CDS is requesting comments on the following short plat application: SP-26-00007
Schultz.

TO: All Staff
FROM: Public Works Plan Review Team
DATE: August 24, 2026
SUBJECT: SP-26-00007 Schultz

SUBJECT: WDFW COMMENTS ON SCHULTZ SHORT PLAT (SP-26-00007)

Subject: SP-26-00007, Schultz
SR 97 MP 143.04 left, Ellensburg Ranches Rd.

Critical Areas

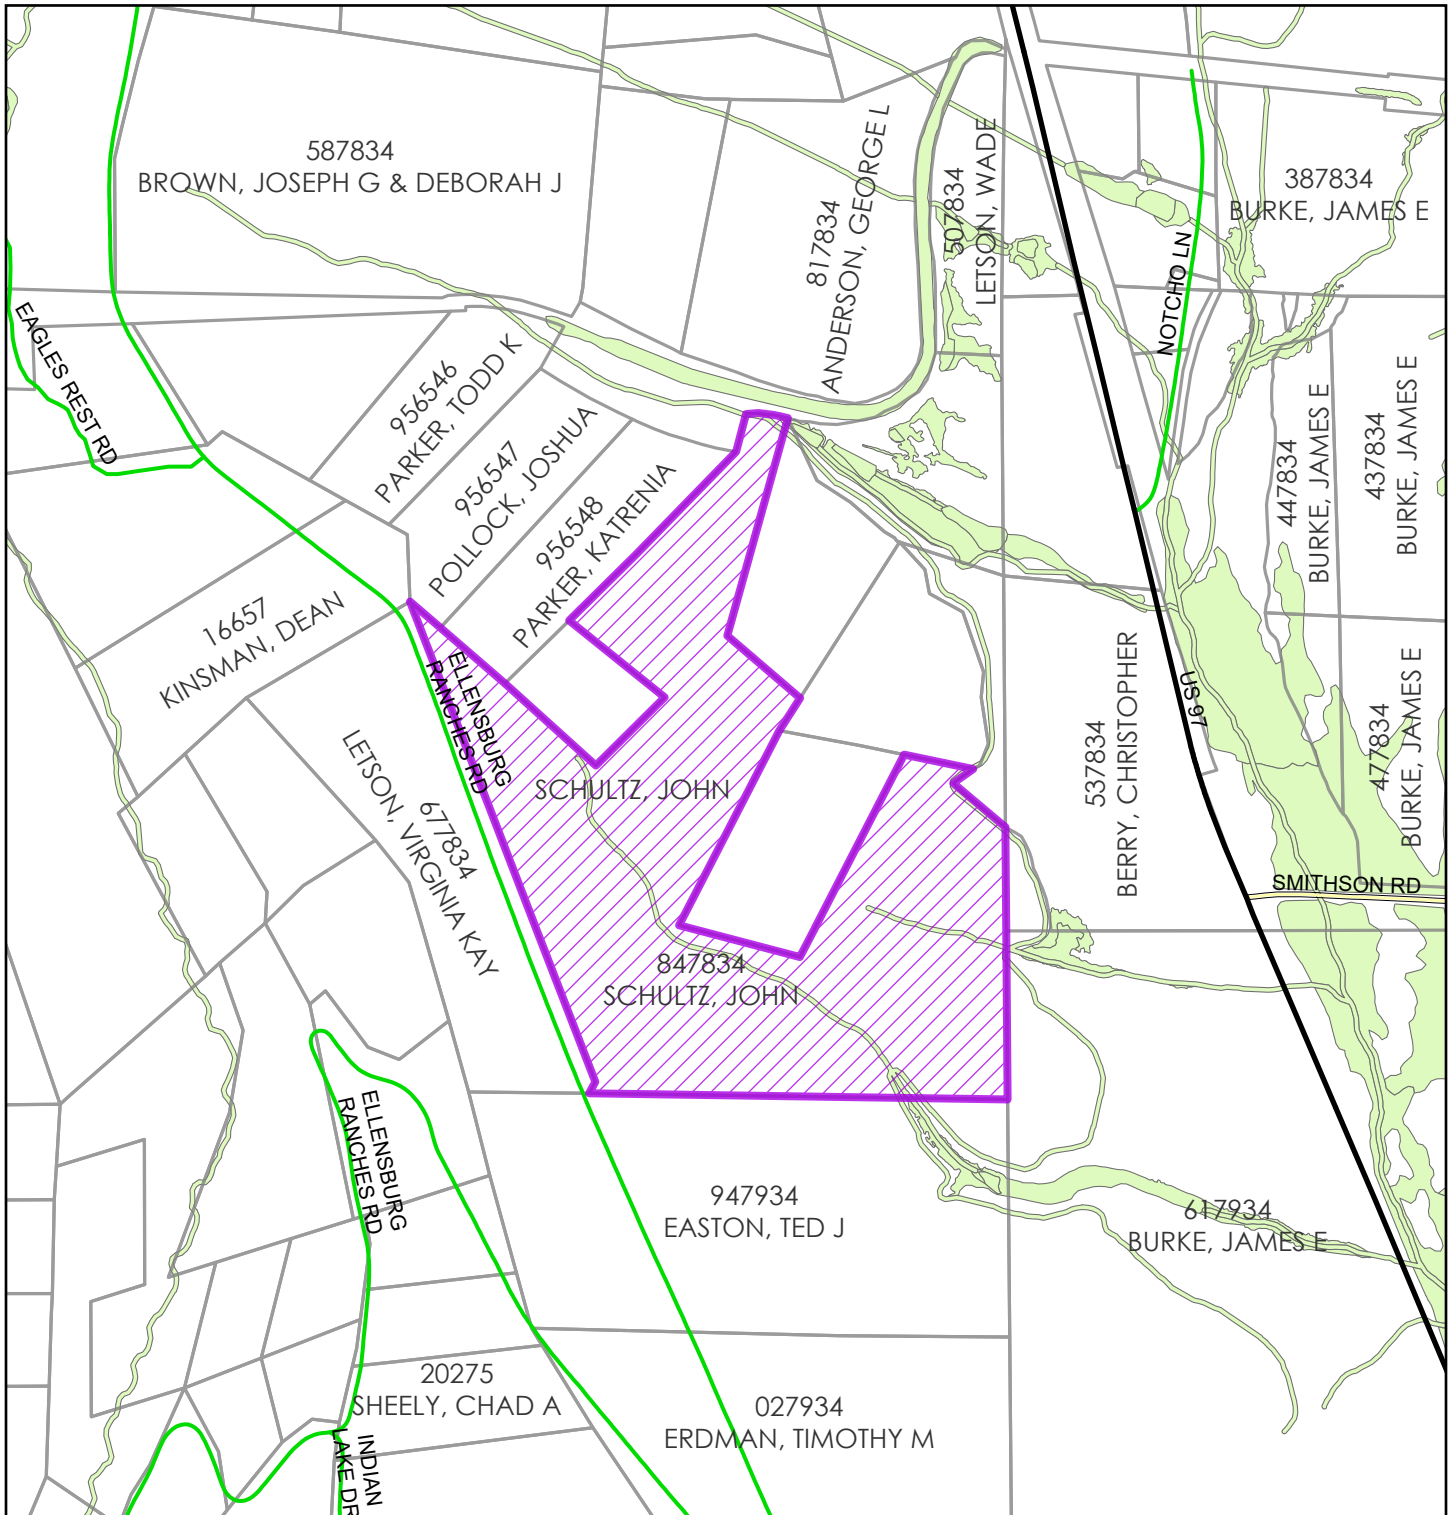
The parcel proposed for this short plat contains shrubsteppe habitat, is Mule Deer winter range habitat, and is located within a Biodiversity Area and Corridor; all are identified in WDFW's Priority Habitats and Species (PHS) program and are designated Fish and Wildlife Habitat Conservation Areas under Kittitas County's Critical Areas Ordinance (KCC 17A.04).

WDFW recommends that these critical areas be included in the Critical Areas Map provided with the application materials and/or as part of the final plat approval. Providing clarity now on the critical areas present will help ensure all future development proposals are aware of these critical areas and the appropriate mitigation measures will be applied to address any potential impacts to shrubsteppe habitat. We would encourage conservation platting to create buildable envelopes on each new parcel with the buildable areas clustered together to minimize disturbance of the critical areas. We would recommend that these building envelopes and impacts on the critical areas be determined prior to final approval of the plat to be consistent with mitigation sequencing in the Critical Areas Ordinance. WDFW is willing to meet with the applicant to provide suggestions on the clustering of the building envelopes to minimize impacts to the critical areas, particularly wildlife movement. All future development on these lots should follow mitigation sequencing to minimize disturbance and mitigate for the unavoidable impacts.
